RE: **Mountain Subdivision**
2406 Mountain Rd NW
Grading Plan Engineer's Stamp Date: 1/8/18
Drainage File: J13D207

Based on the information provided in your submittal received 1/10/18, the Grading Plan cannot be approved until the following are addressed.

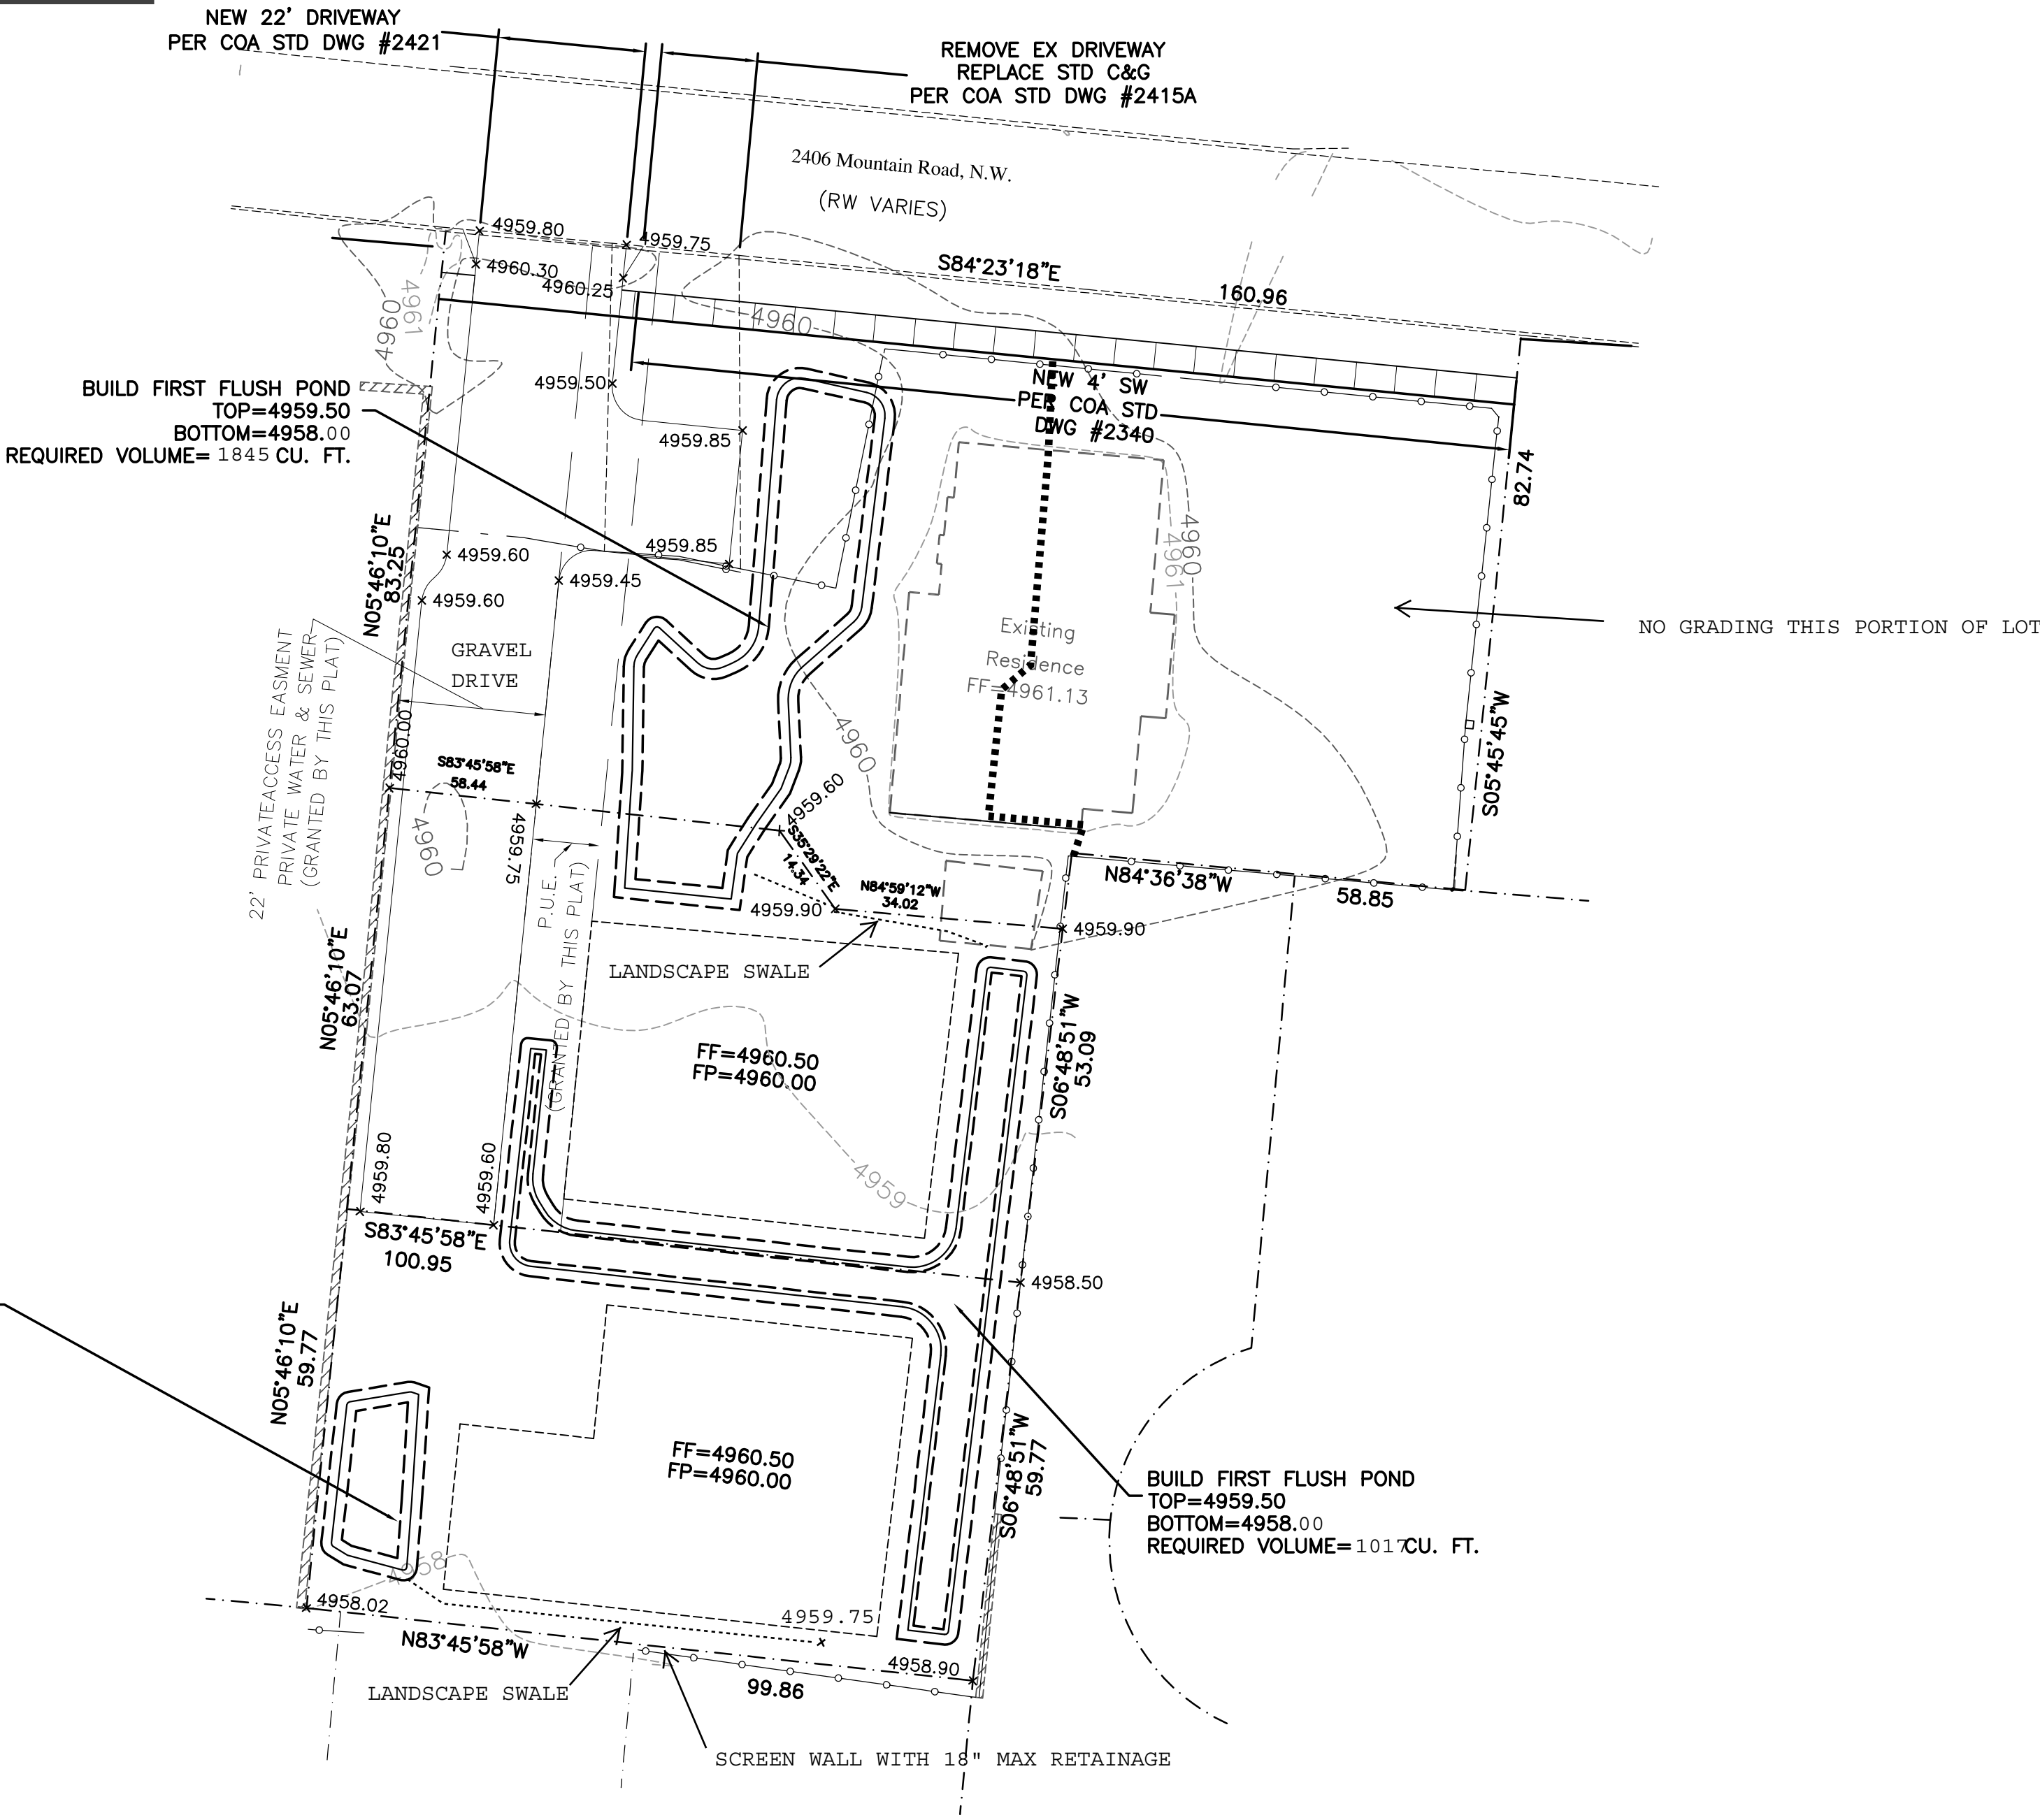
1. Provide onsite ponding volume on each lot for the 100-year, 10day volume; infiltration rates cannot be accepted in lieu of this volume requirement.
2. Please add swales along the side yards to direct runoff into the ponds.
3. Ensure that the Preliminary Plat includes cross lot drainage easements identifying maintenance and beneficiary responsibilities to support the ponds crossing the lot lines.
